Your Ref: OWPC24679
Our Ref: M/80/19/PL 16-09-2019
Please ask for:
Mrs A Gardner

Demolition of the existing structures & redevelopment to provide a new 66-bedroom care home (Use Class C2) arranged over two storeys together with associated access, car and cycle parking, structural landscaping and amenity space provision
Former Poultry Farm Land West of Yapton Road Middleton on Sea

Thank you for your internet representation made on 22nd October 2019 which has been recorded as '**an objection**' with the comments as follows:

PROPOSED ACCESS ARRANGEMENTS

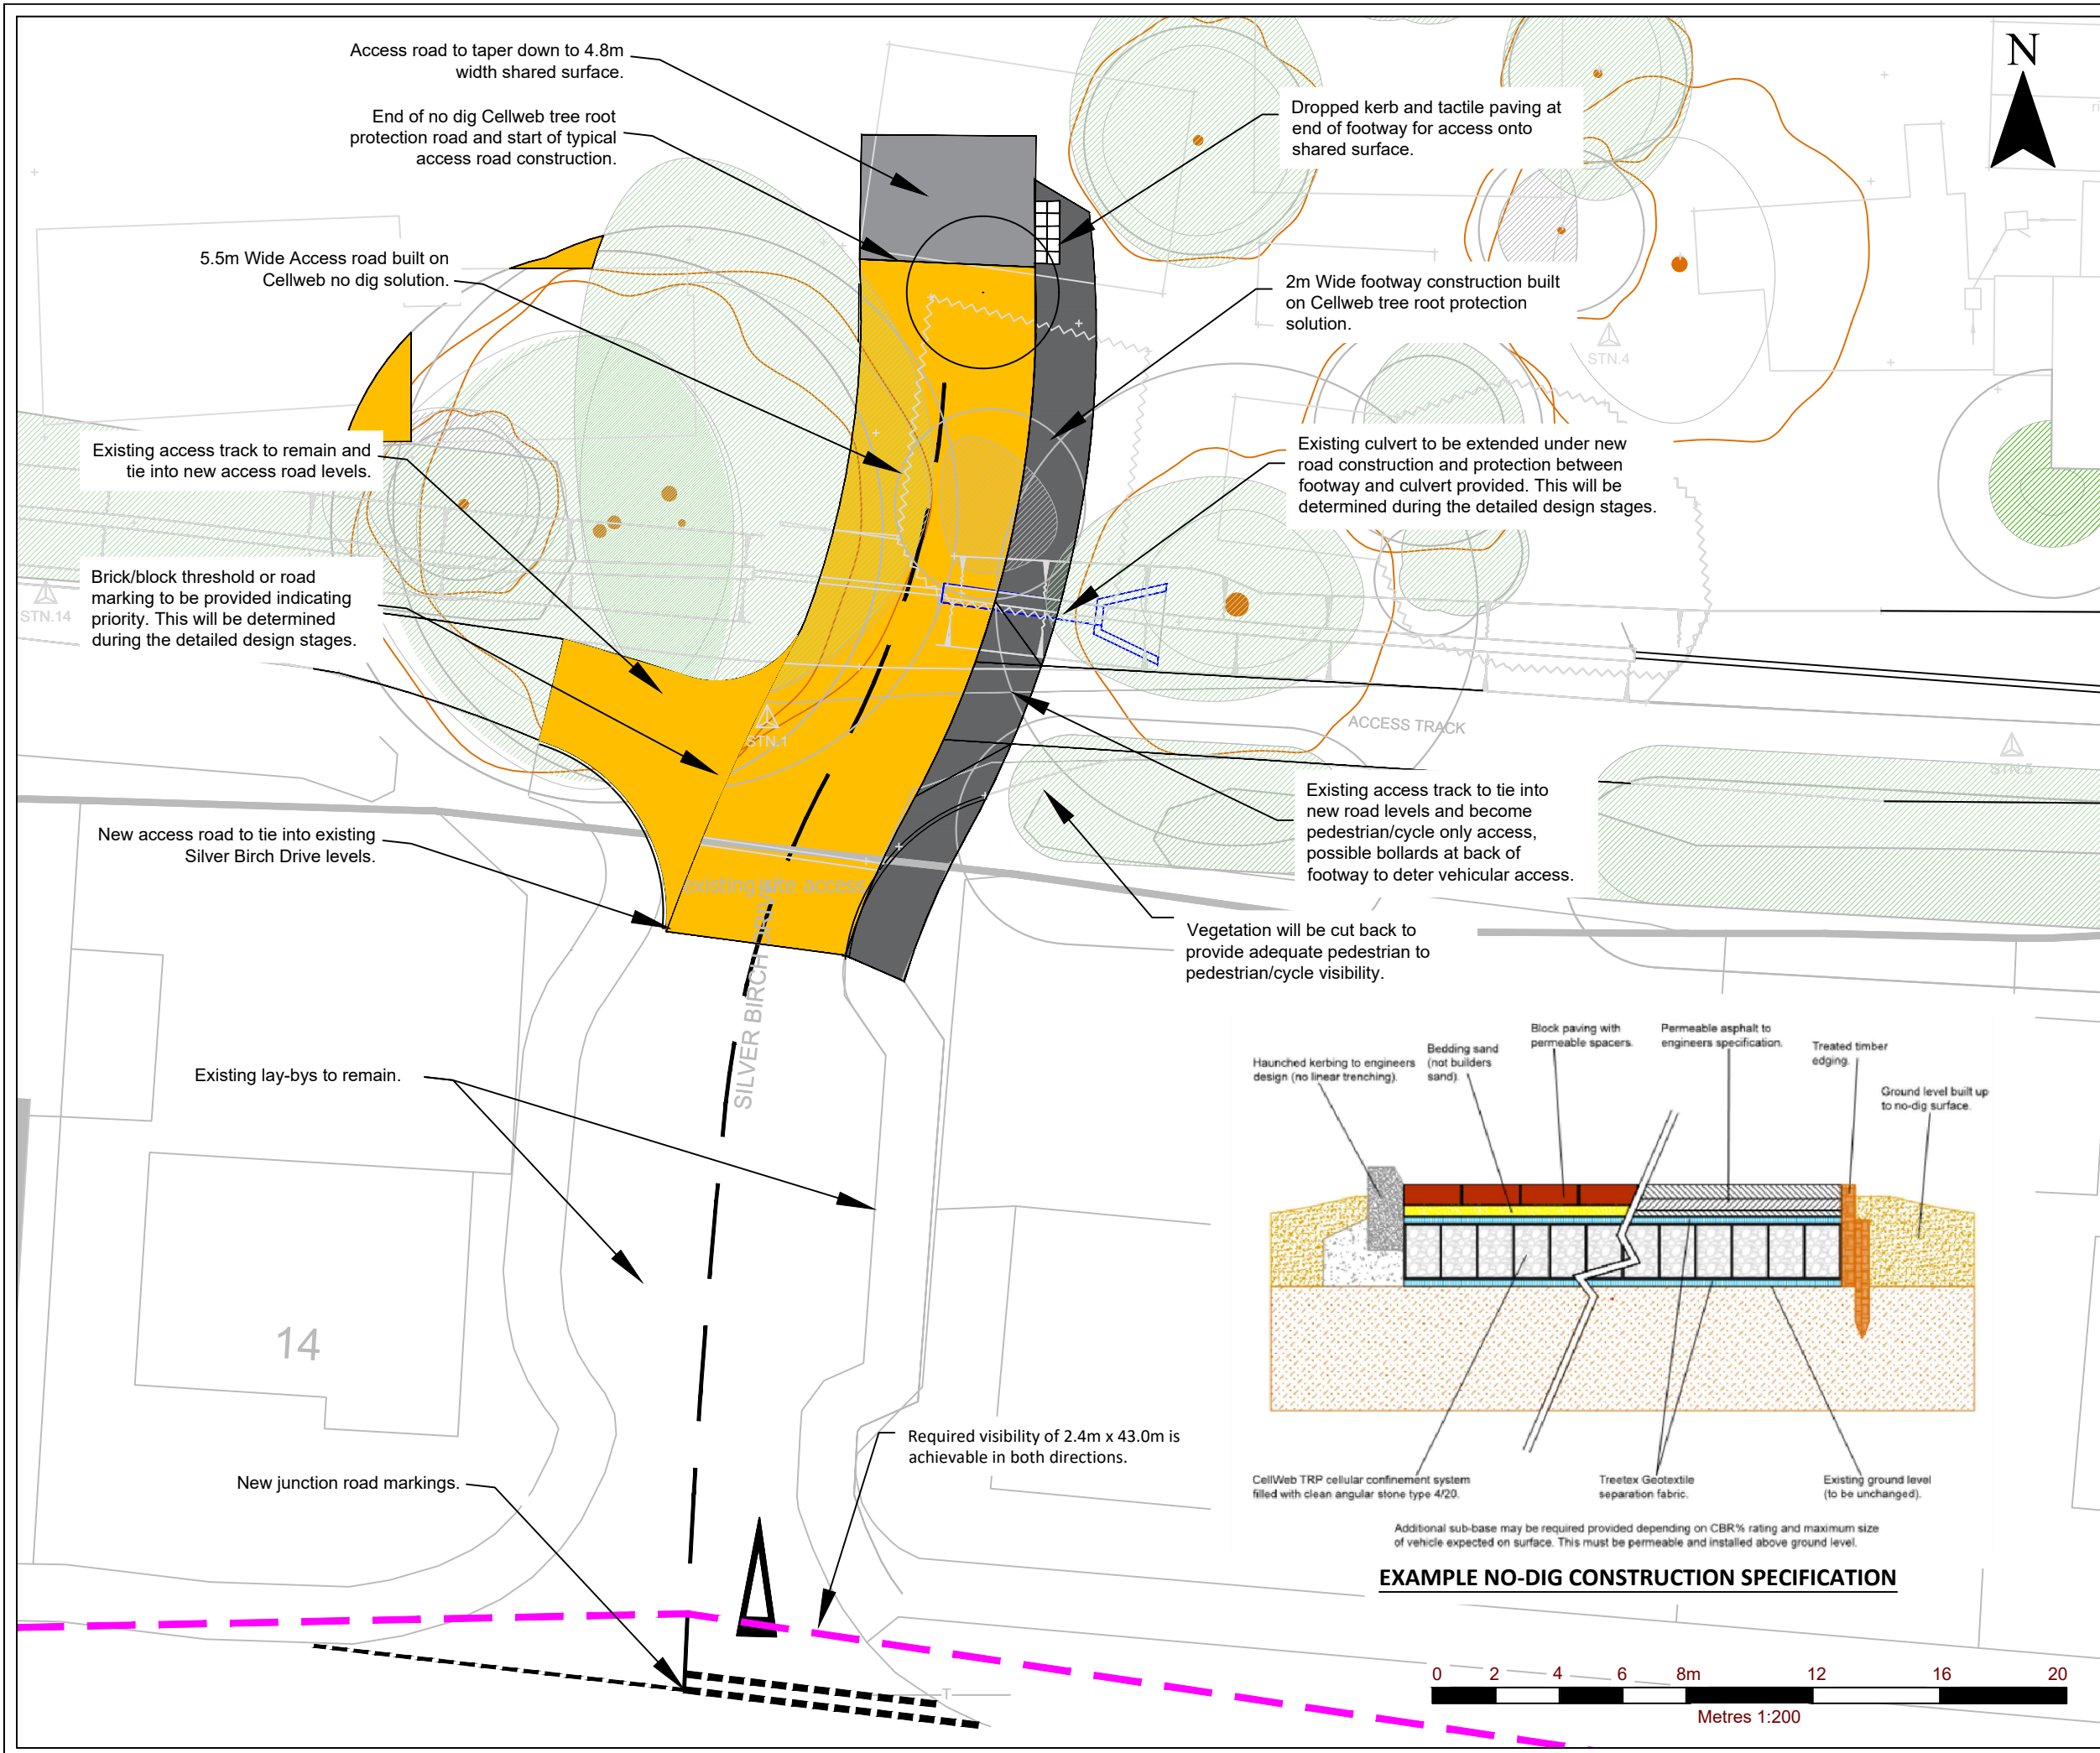
Regarding the Substitute Plan, the drawing shows the access road with markings as if it were a standard two-lane road. It is not - and it is very disturbing to see it portrayed inaccurately as such to the council by the developer and its paid agents, especially given the 145 vehicles a day at least the applicants plan to put down this small side road.

Two-way access will not be possible down that access road the majority of the time, certainly if a larger vehicle like an SUV or van is involved. This is a very important fact, because if two way traffic is not achievable in practice much of the time, this will have severe obstructive implications back on the busier Silver Birch Drive and its community.
